## Review of 8.85 APPLICANT'S RESPONSE TO COMPULSORY ACQUISITION HEARING 1 ACTIONS 14-17: WIGMORE VALLEY PARK

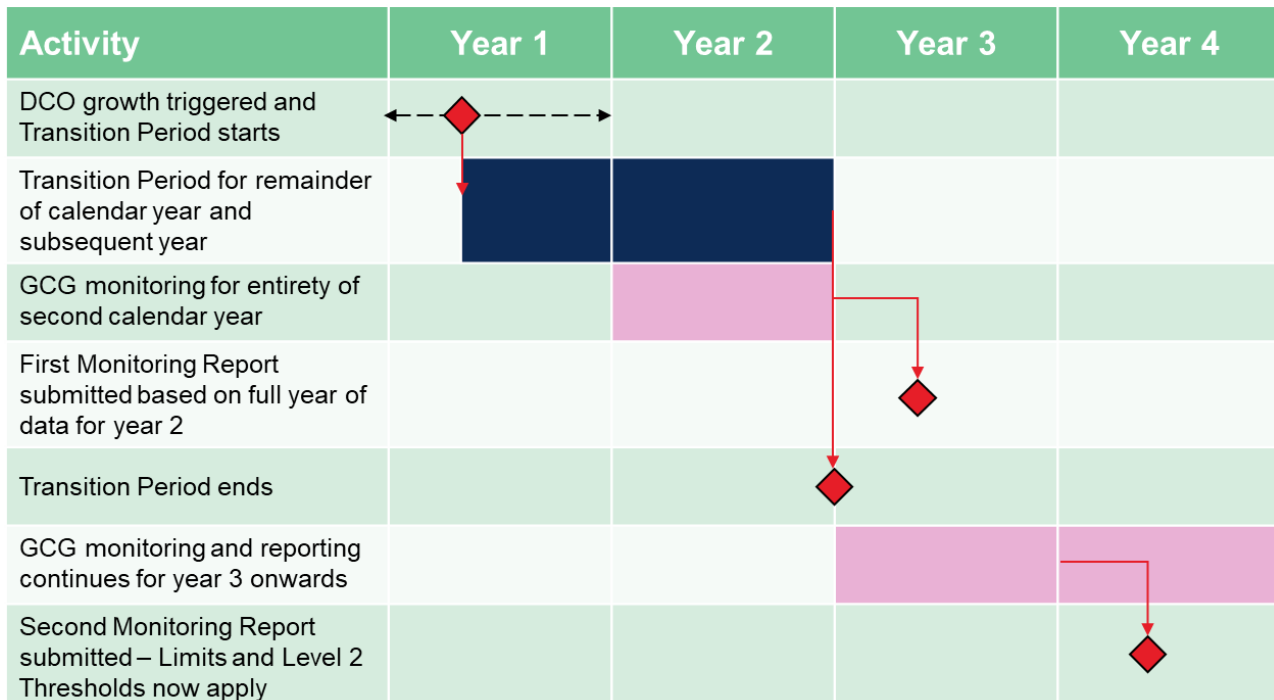
The equivalence demonstrated in **figure 3.1 & figure 3.2** is misleading. 3.1 demonstrates a walk around the perimeter of the existing park taking in lots of different perspectives, whilst 3.2 demonstrates a walk up and down a narrow strip of the replacement park. The equivalent experience would require a 3.5km walk.
